~~with 11/11~~
LU/99/11

Our Ref: HJA/EH/15/10

Re: Planning application – West Beach Café

PLAN OF PROPOSED W.C.'s AND STORAGE UNIT LOCATED AT WEST BEACH CAFE, LITTLEHAMPTON. BN17 5DE.

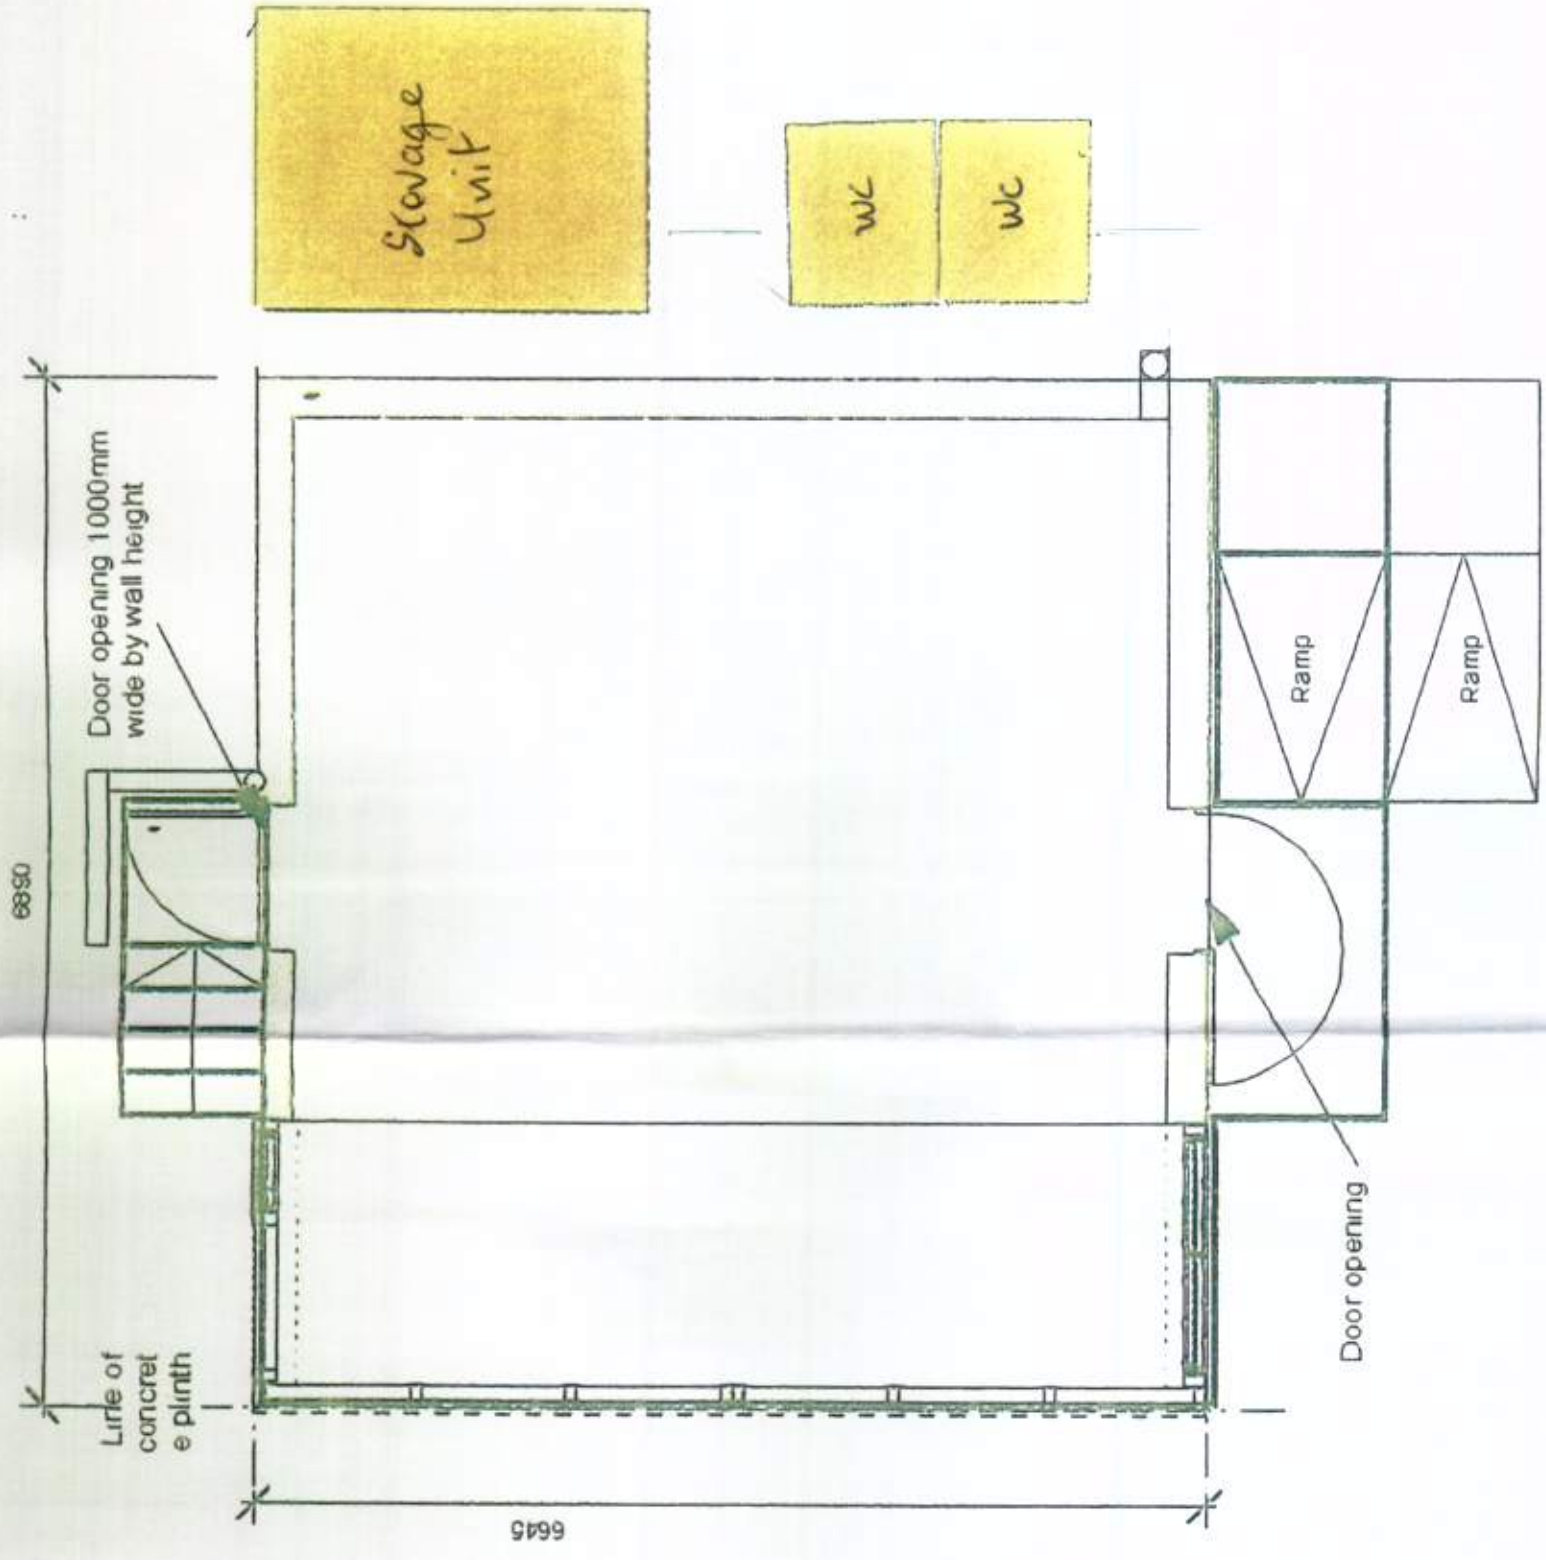
The proposal contained within the submitted planning application shows a metal container as a storage facility. The nature of a metal container is that there is likely to be condensation present unless it is adapted to include adequate ventilation. An environment

in which there is condensation is unsuitable for the storage or handling of open food and food which is not in impermeable packaging.

Furthermore, the plans of the proposed layout show that to access this container from the cafe, would necessitate walking outdoors where it would be open to airborne contamination. To avoid contamination of food during transport between cafe and store (and vice versa) open (un covered/packaged) foods should not be transported between the cafe and store.

You may wish to consider an extension to the cafe which is accessed directly from the cafe and which is well insulated and ventilated as this would provide a more versatile space which would allow a wider range of food to be stored, and also prepared if suitable materials are used. If you would like any further information on the structure of the premises, including layout and materials, please contact the Environmental Health's Commercial team who will be happy to advise.
